InterContinental Hotel and Transport House, Sydney – Concept Development Application (Staged Development) for Alterations and Additions (SSD 7693)

Submission by John Freeman

SETBACK DIAGRAM | VIEW FROM NORTH-EAST

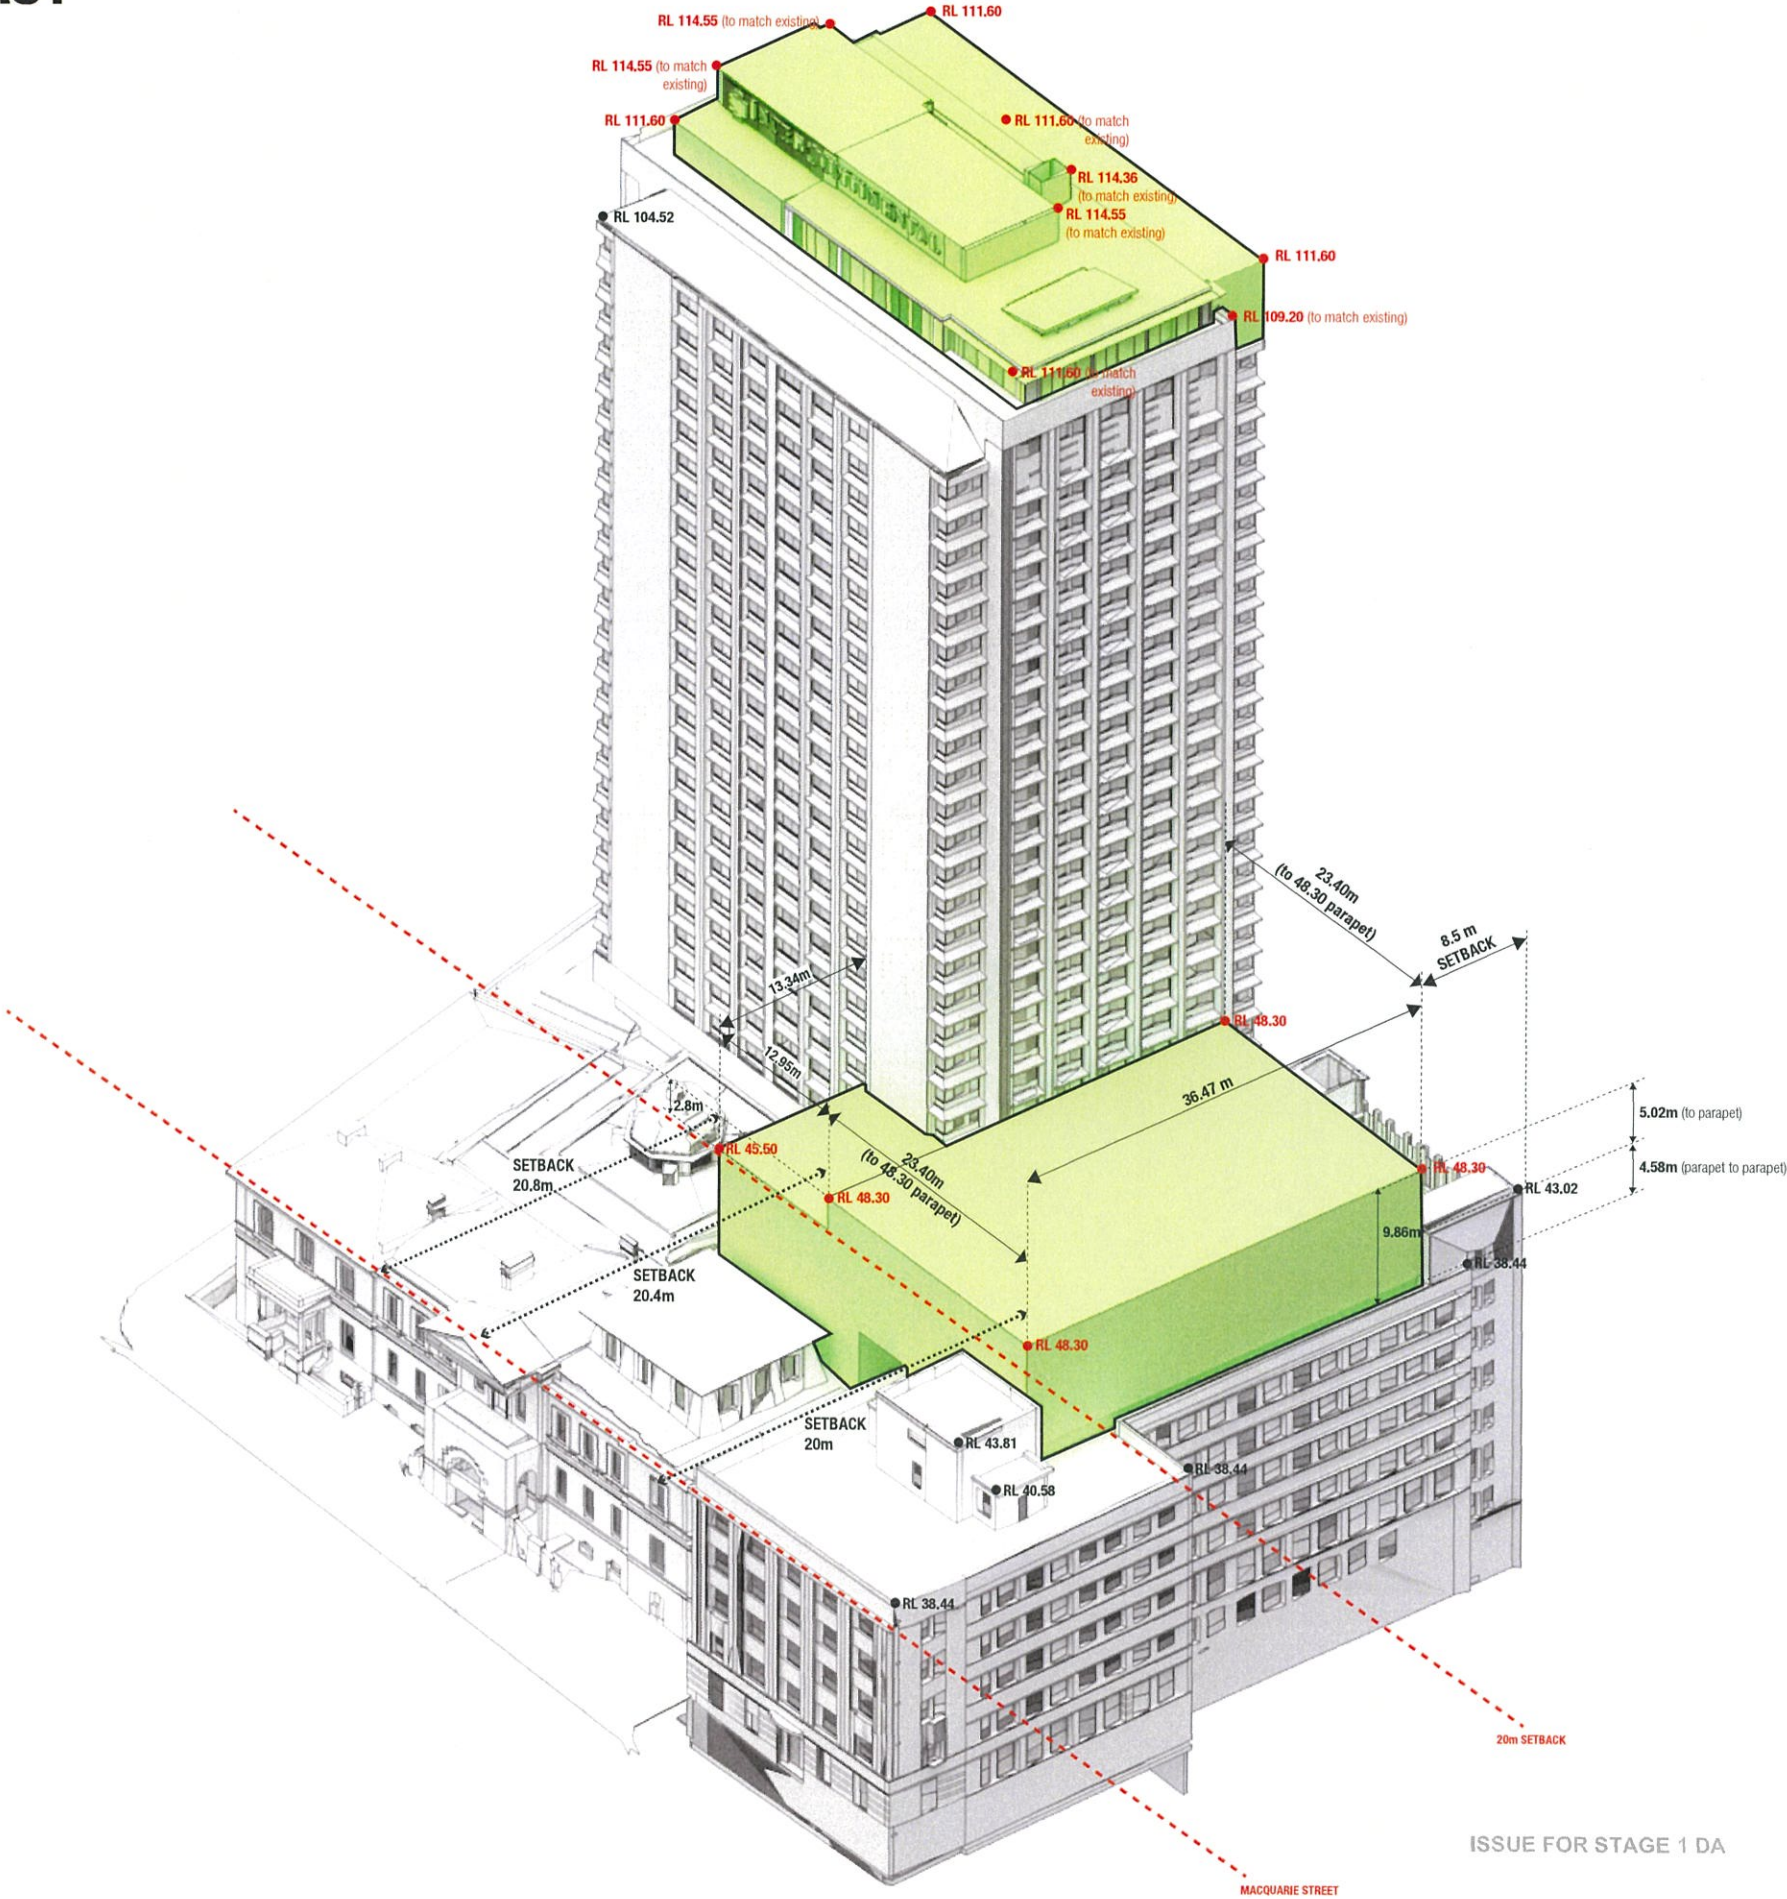
The EIS does not adequately discuss setbacks. There is no mention of the DCP 10m setback on Bridge Street, yet the drawings propose a mere 4m setback. The mechanical plant will be visually prominent and detract from the heritage façade below (see picture below).

The relocation of mechanical plan is a wholly inadequate justification for non-compliance with the Bridge Street DCP setback.

The DCP requires a 10.0m setback from the Phillip Street wall yet the proposed grand ballroom addition would extend to the street frontage. The application documents consider only the impacts of this on heritage values. The DCP explains that the purpose of setbacks is to protect the quality of the public domain, and the application does not assess the impacts on the public domain of Phillip Street from having no setback. At the very least a zero setback would reduce sunlight access to the pedestrian pavements.

So His Honour Justice Bignold considered that a 3m setback was insufficient, but the applicant is proposing no setback whatsoever. Although the height of the proposed northern façade is lower than that which Justice Bignold considered, it is much wider.

SETBACK DIAGRAM | VIEW FROM SOUTH-WEST

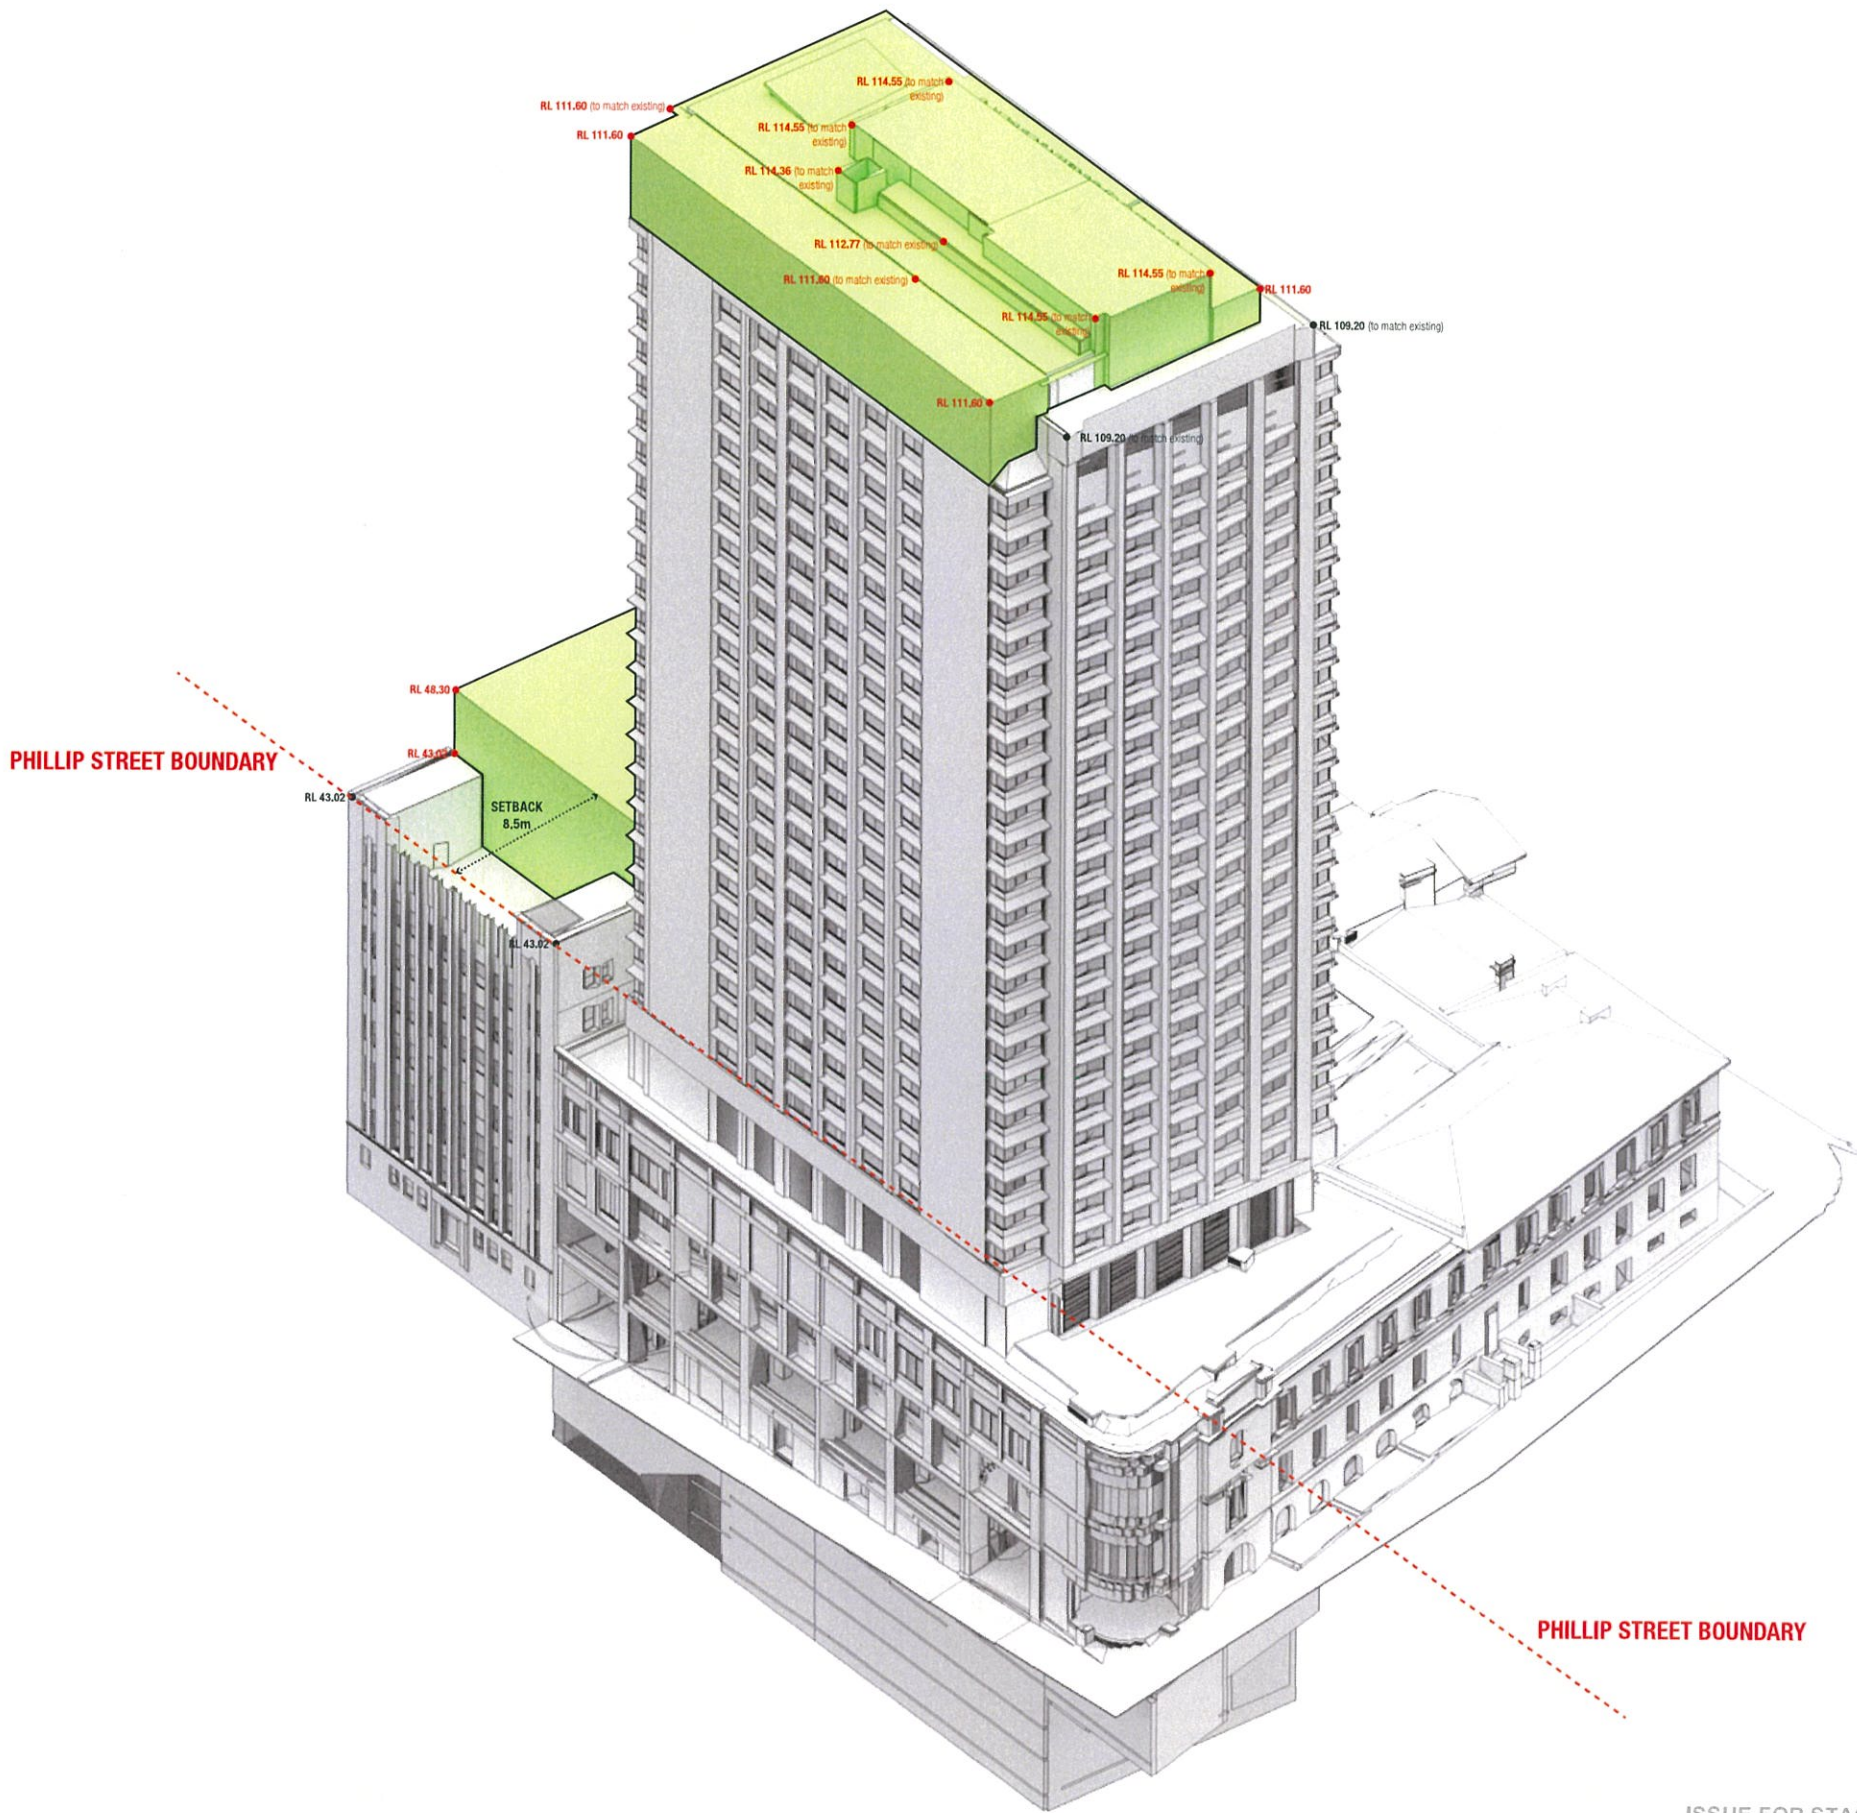
The EIS proposes no setback from the northern boundary of the site. In *A.P.T. Peddle Thorp & Walker Pty Ltd v. Sydney City Council* (NSWLEC 186 (4 December 1997)), His Honour Justice Bignold stated:

To the extent that cl 7(3) warrants consideration of the impact of the tower proposal on the adjoining heritage buildings to the north of Transport House I would find, preferring again the evidence adduced by the Council, that there would be an adverse impact on those heritage buildings, by virtue of the elimination of the present transition in scale between the low rise Justice and Police Museum buildings, through the mid-rise Transport House to the high-rise Inter-Continental Hotel and its replacement by the high-rise tower (set back only 3 metres from the northern boundary) which would visually overwhelm the low-rise heritage buildings.

The SEARs call for the EIS to consider the setbacks of the proposal within the context of the locality and heritage values, yet it has not done so at all in respect of the northern and southern setbacks, and has only provided a partial consideration in respect of the Phillip Street setback.
